Subject: RE: Follow up on our conversation on FSRU Port Kembla [External Sender]

Based on our conversation from the past Thursday, you agreed to provide additional justification on the following items:

NSW Department of Planning & Environment

Figure 8 | Berth 101 Fatality Risk Contours

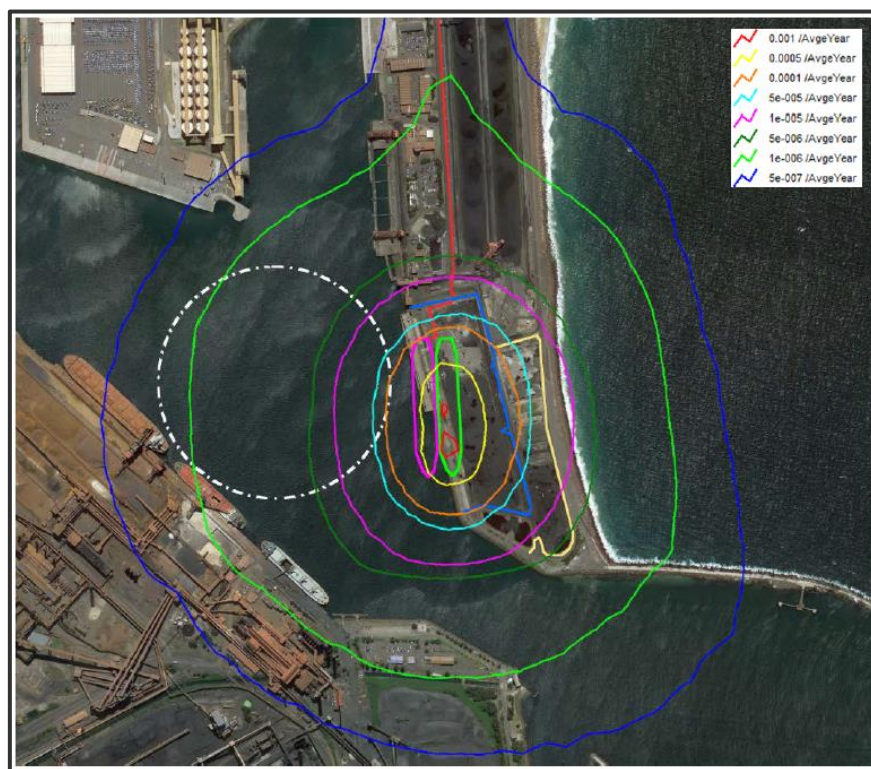
1. LSIR encroaching to PKCT existing truck wash area.

[Fergusson, Andrew (Brisbane)] The current location of the 1E-05 contour extends beyond the proposed eastern site boundary and is west of PKCT Truck Wash. This area is not normally occupied and PKCT have advised AIE that the truck wash is a back-up to their northern truck wash and would only be used rarely if the northern truck wash is out of service. When in use occupancy of truck drivers is expected to in the order of minutes not hours. Hence, occupancy per annum will be low. The equipment adjacent the truck wash undergoes maintenance for a period of 2-3hrs once per quarter. Again occupancy per annum will be low. The risk contours presented in the existing PHA take no credit for fire or gas detection, or emergency shut down and blowdown and are therefore conservative. With further detailed assessment some contraction of the contours may occur.
